**Cotswolds
National
Landscape**

PINS REFERENCE NO: EN010168

DESCRIPTION: Development consent to construct, operate, maintain and decommission a solar photovoltaic (PV) generating station, with a generating capacity of more than 50 megawatts (MW) and associated infrastructure

LOCATION: Lime Down Solar Park, Wiltshire

LIME DOWN SOLAR PARK
Figure 3-4-1
Lime Down Solar Park - Site A
Landscape and Ecology Mitigation Plan - Revision 3
END10168/APP/6.2
5(2)(a)

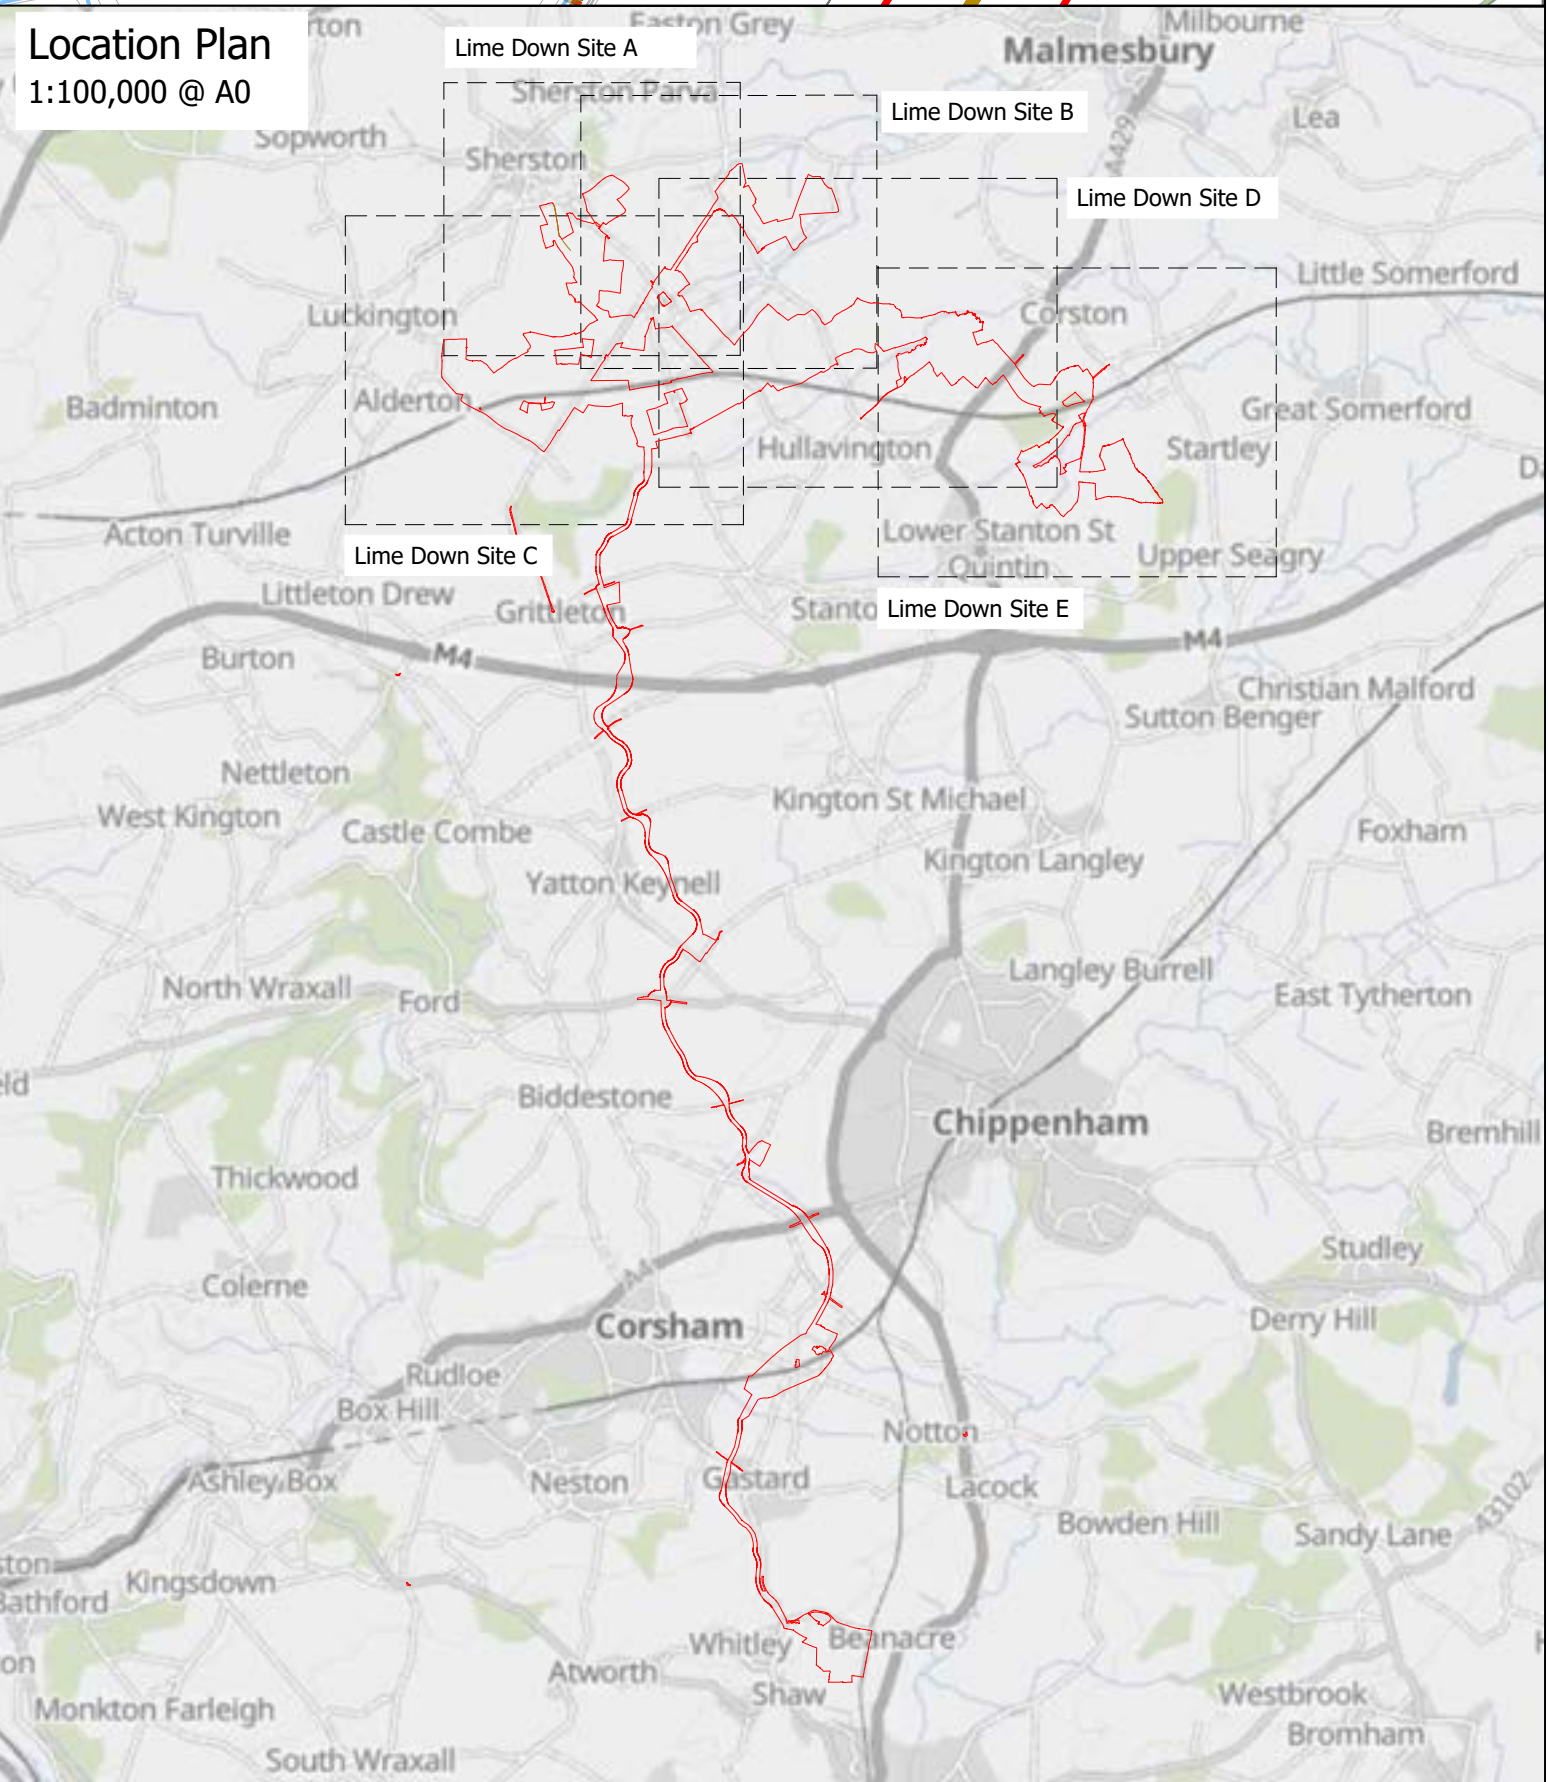
ExQ1 LV1.11 1): *With regards to PMIE 3, the applicant and the CNLB are asked to clarify how its recommendation that consideration should also be given to removing the southern part of Field A1 was dealt with and whether the CNLB still consider that panels should be removed in this location?*

CNLB Response: The Board notes the draft Statement of Common Ground with the Cotswolds National Landscape Board (May 2026, Revision 1, REP2-029) and the Applicant's position on this matter which is stated at Reference 3.1.17, page 14 of the document: "*The final iteration of the Scheme includes the avoidance of panels in the southern part of Field A1, the remainder of Field C6 and Fields C7. These areas*

are identified for habitat enhancement" (our emphasis). As such the Board understands and supports the Applicant's position that Solar PV panels are to be removed from the southern part of Field A1.
